Please ask for: Sian Eggington
Email: sian.eggington@terraquest.co.uk
Telephone: 0121 2341390
Our Ref: BR/120/20/HH
Your Ref:
Date: 11th June 2020

Application for Planning Permission for Works or Extension to a Dwelling

Development: Proposed Garage Conversion To Granny Annex
Location: 32 Victoria Road Bognor Regis PO21 2JF

Existing & Proposed Plans

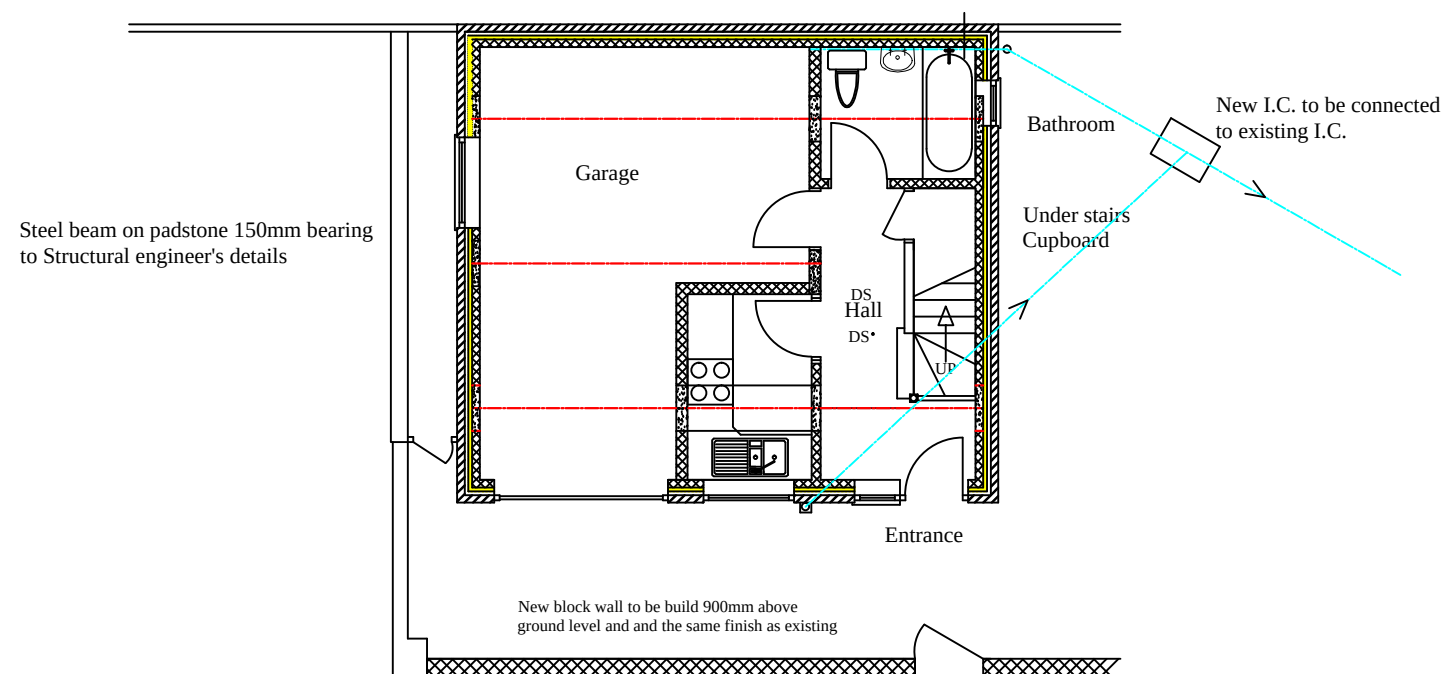
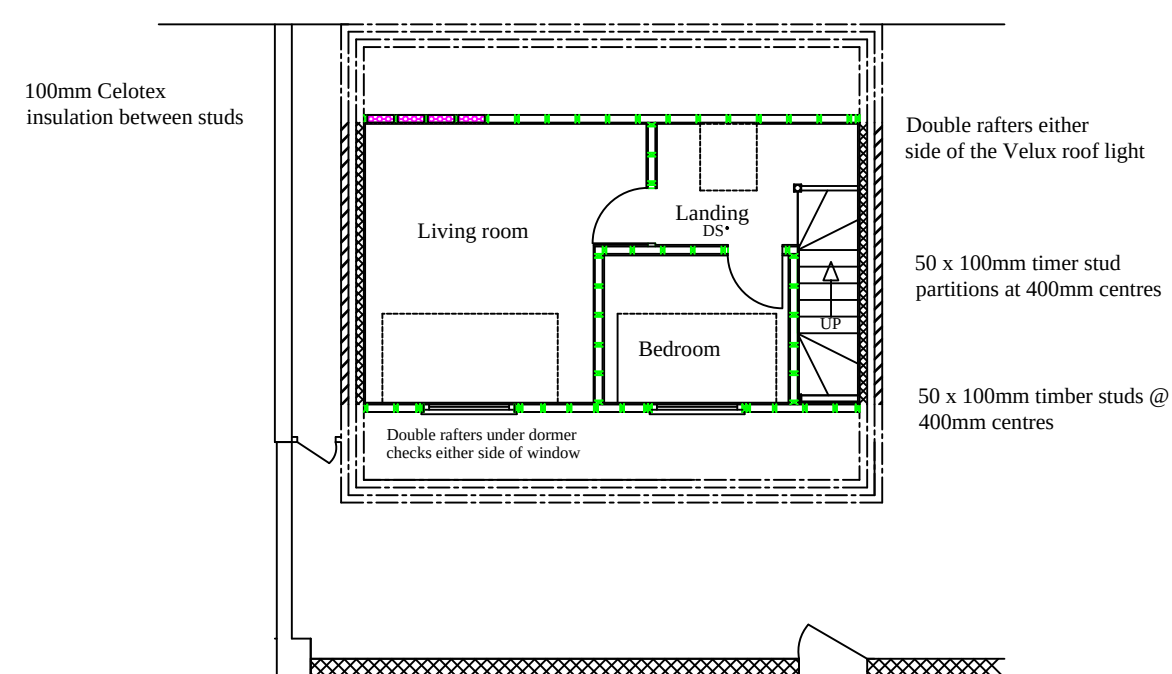
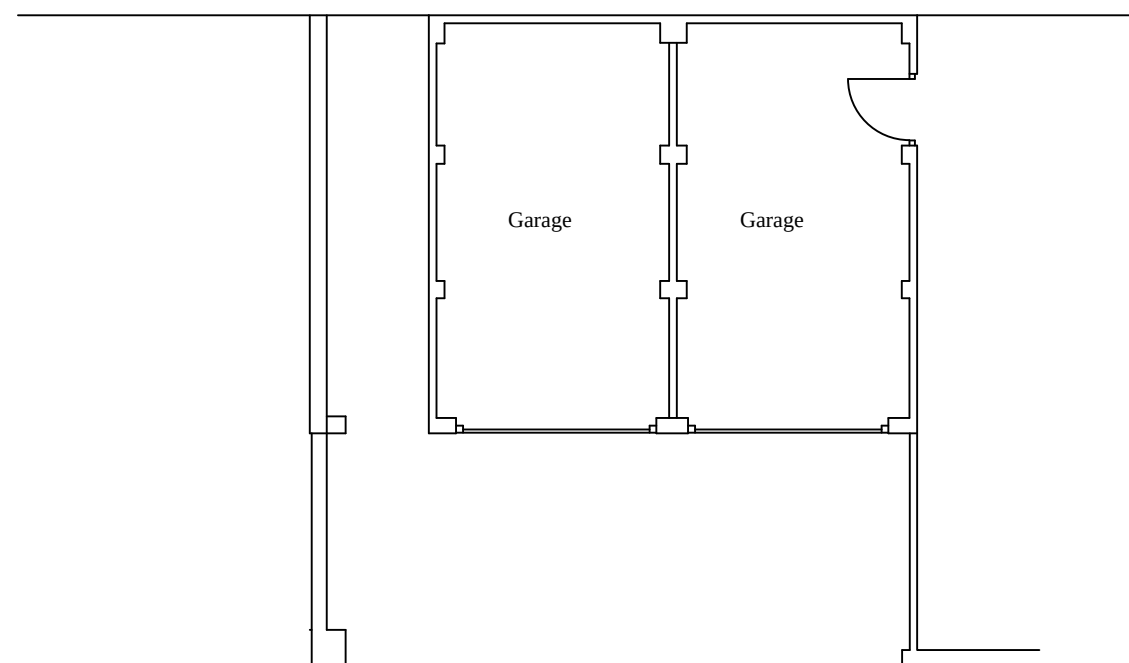
Description: Please confirm whether you are demolishing and rebuilding the existing garage or extending the garage and update the description as necessary.
